Our Ref: 20/01333/HOU
Your Ref: Augustine Road,
Portsmouth

LOCATION: 32 Augustine Road, Portsmouth, PO6 1HZ

PROPOSAL: Installation of additional bedroom window to existing South facing dormer **(20/01333/HOU)**

Project : Proposed additional dormer window to:
32 Augustine Road, Drayton, Portsmouth.
Client : Mr Chris Jenkins
Title : Existing & Proposed Elevations
Drawing : Y9020_A8-02 / Rev A

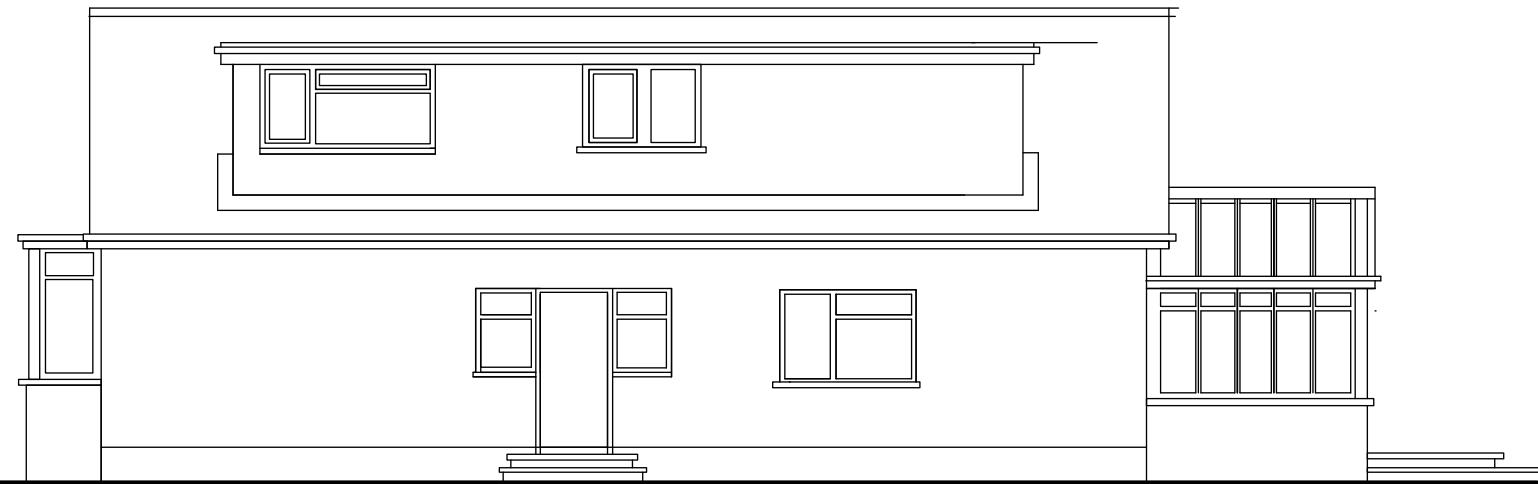
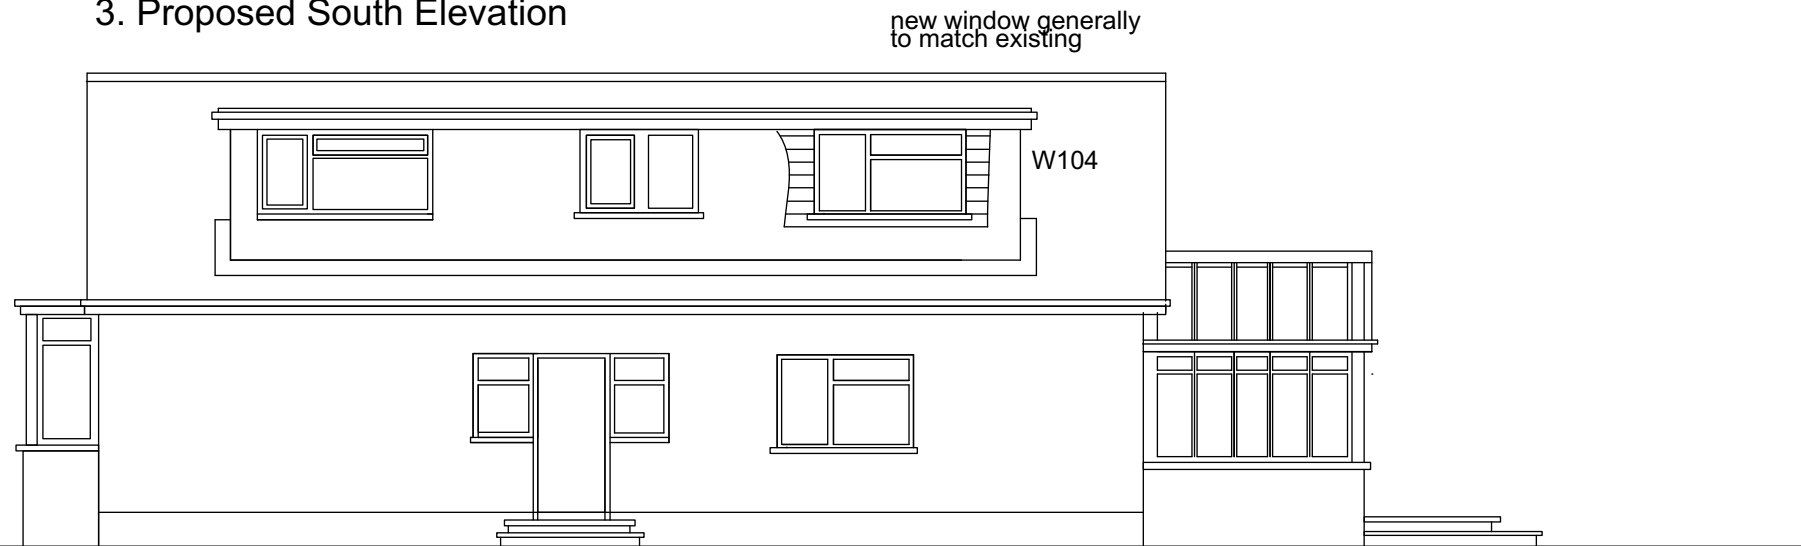
- 1) Existing & Proposed Plans have no scale bars

It is a requirement that all drawings are accompanied by scale bars for every sized used. Please resubmit your drawings with the appropriate scale bar(s) included.
